Our Ref: TR010064

Date: 30 April 2024

Application by National Highways for an Order Granting Development Consent for the M60/M62/M66 Simister Island Interchange Project

Advice following issue of decision to accept the application for examination

Plate 2.1 3D model of Simister Pike Fold Viaduct

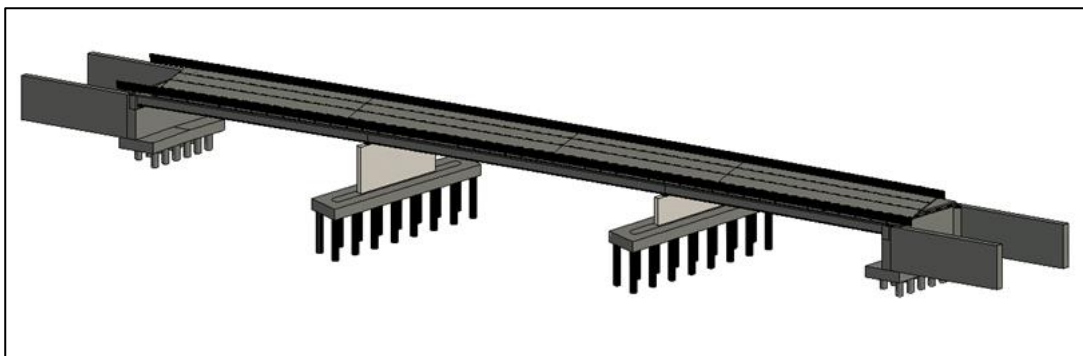
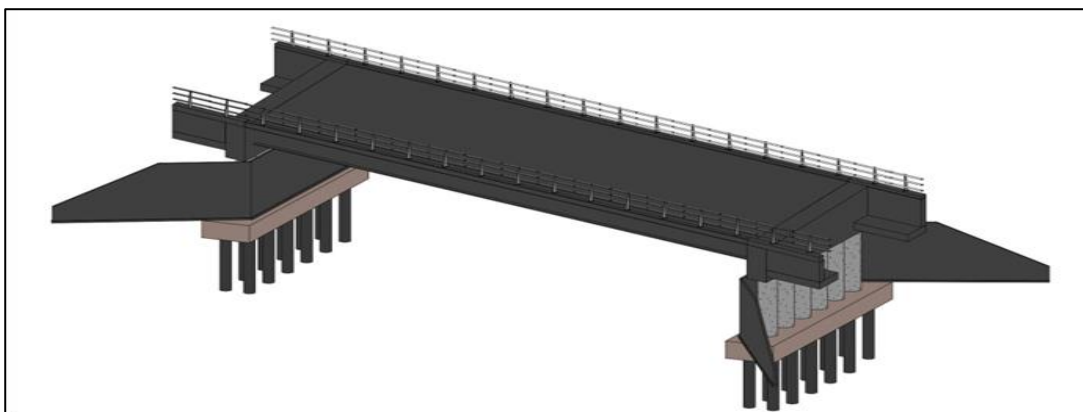
The scheme design report (TR010064/APP/7.6) identifies the Pike Fold Viaduct and Pike

Fold Bridge as “prominent new structures”.

There do not appear to be plans provided which show the details of the external appearance and means of landscaping, that would meet these requirements.

It is recognised that there are engineering drawings (sections and elevations) for the Pike Fold Viaduct and Pike Fold Bridges are included in the application. However, in the absence of additional visualisations, it is difficult to understand how the scheme may appear on the ground, and what vision is expected to be delivered to achieve a design that would deliver a scheme that would meet the tests of good design which is a thread through the NPS for National Networks. While it is understood a finalised design may not be presented at this stage, sufficient information clearly demonstrating the design vision, and the approach taken to achieve this should clearly be presented.
